Consultation Response from: KC Environmental Health (Pollution & Noise Control)
2021/92009 - Union Mills, Tanyard Road, Milnsbridge, Huddersfield, HD3 4NB

Discharge of conditions 3 (preliminary risk assessment), 9 (drainage scheme), 10 (internal sound levels), 11 (ventilation scheme), 12 (flood evacuation plan), 13 (soft landscaping), 14 (construction environmental management plan), 15 (landscape and ecological management plan), 17 (bat roosting feature), 18 (electric vehicle charging), 19 (public open space), 20 (travel plan) and 21 (crime prevention) on previous permission 2018/90209 for change of use and alterations to mill to form 41 apartments (within a Conservation Area)

**Responding Date:
22 June 2021**
**Responding Officer:
Mohammed Nasim**
**Responding Ref:
WK/202116114**

Ref: drawing no. (100)50 rev A : CAR CHARGING POINTS PUBLIC OPEN SPACE (POS) & LANDSCAPING DETAILS May 2021

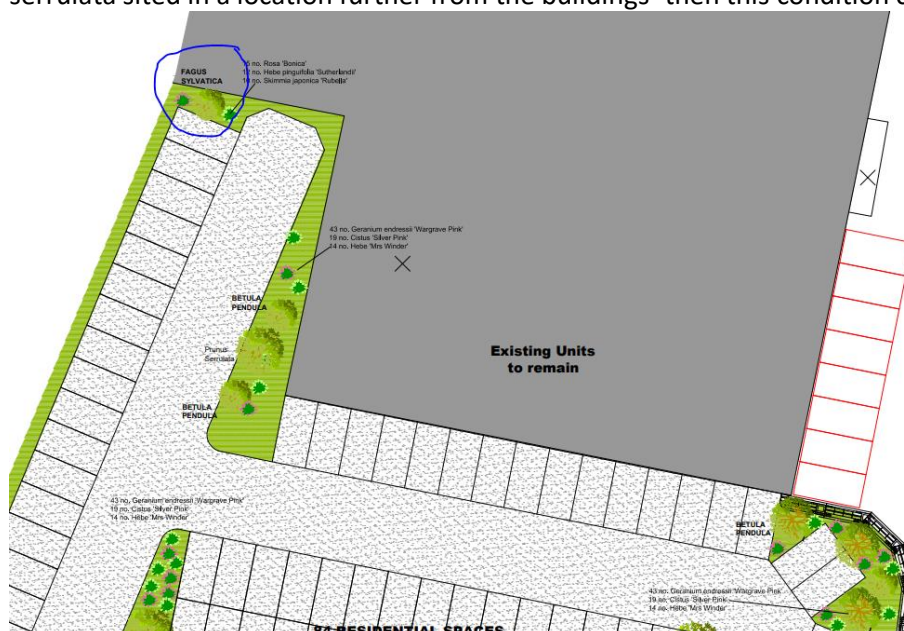
The applicant has submitted a technical drawing no. (100)50 - Car Charging Points Public Open Space (Pos) & Landscaping Details dated May 2021 Ref 2466 which shows 11 electric charging points but no specification is given on them.

I recommend this condition is not discharged until the exact number and specification for the Electric Vehicle Charging Points is submitted.

To assist the applicant, the installed scheme shall meet at least the following minimum standard for numbers and power output:

- A Standard Electric Vehicle Charging point providing a continuous supply of at least 16A (3.5kW) for each residential unit that has a dedicated parking space
- One Standard Electric Vehicle Charging Point providing a continuous supply of at least 16A (3.5kW) for at least 10% of residential parking spaces that are not allocated to specific dwellings

A Standard Electric Vehicle Charging Point is one which is capable of providing a continuous supply of at least 16A (3.5kW) and up to 32A (7kW). The higher output is more likely to be futureproof.
